OUT18/9122

**Sydney Football Stadium Redevelopment - concept proposal and demolition
(SSD 9249)
EIS**

I refer to your email of 12 June 2018 to the Department of Industry (DoI) in respect to the above matter. The department has assessed the proponent's concept development application, including the Groundwater Impact Assessment, and requires the following to be addressed prior to approval. Any further referrals to DoI can be sent by email to landuse.enquiries@dpi.nsw.gov.au.

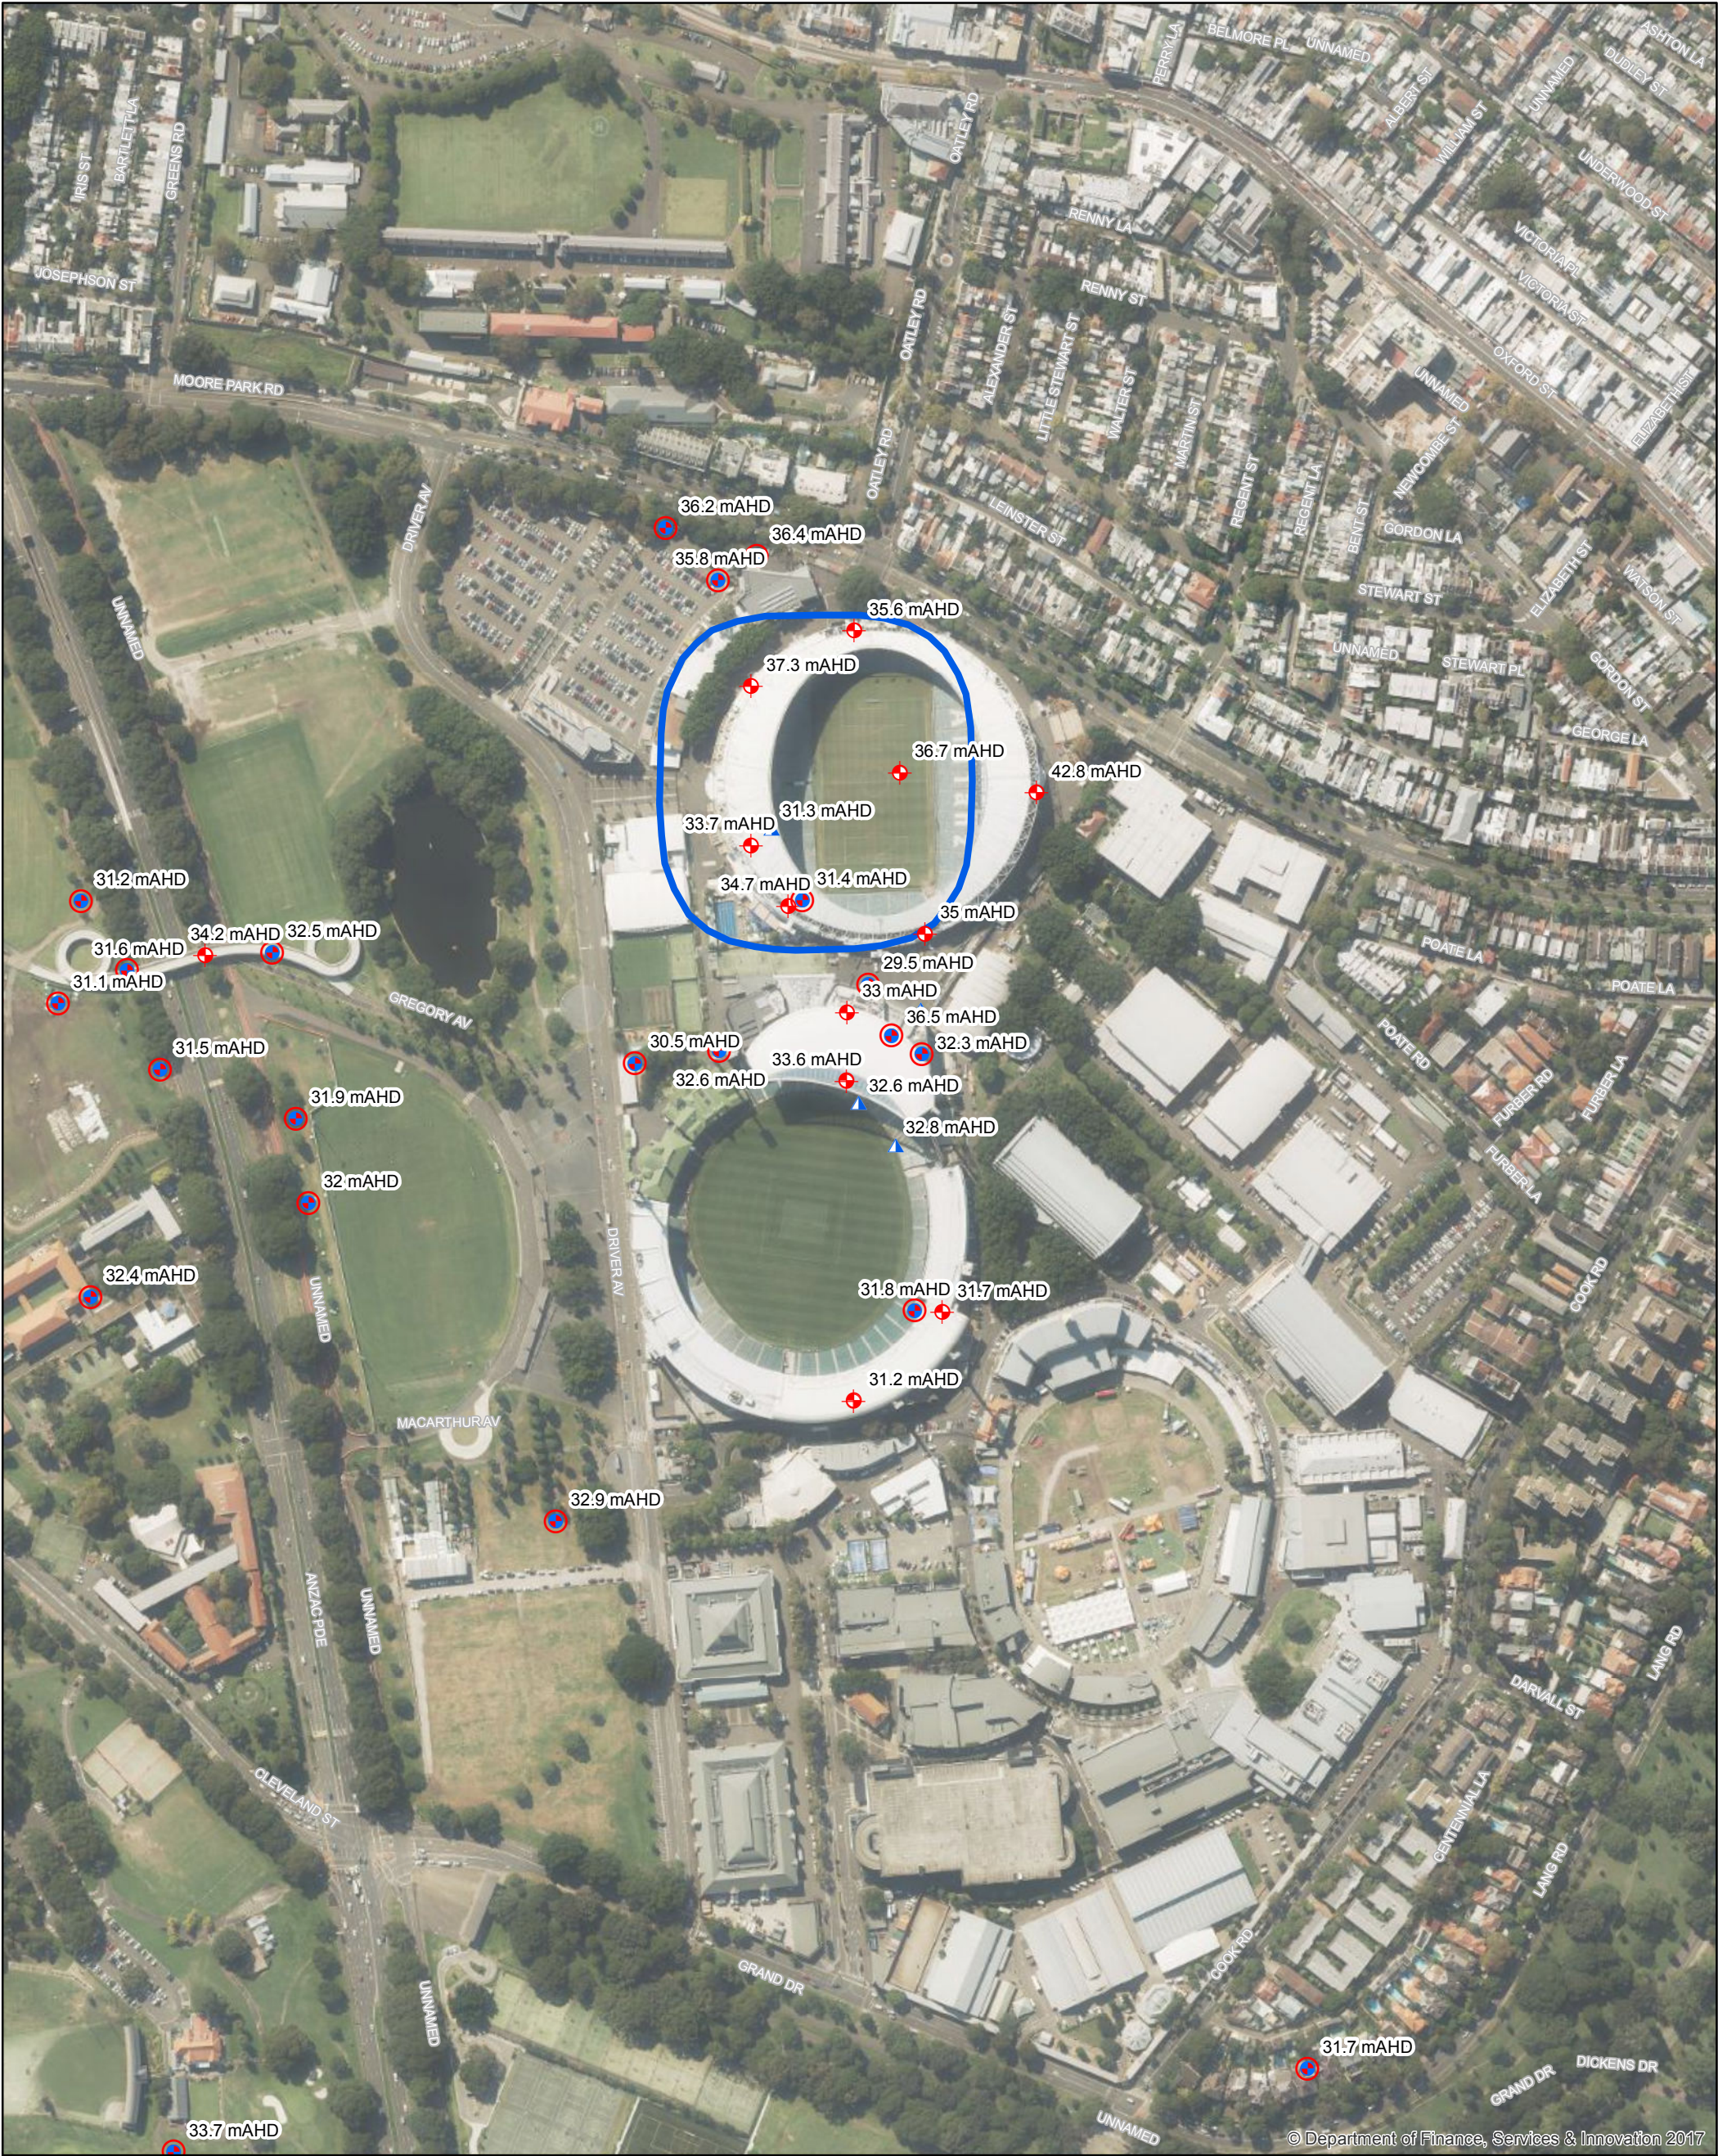
- Ground contours should be shown on Figure 9 in the Groundwater Impact Assessment for reference.
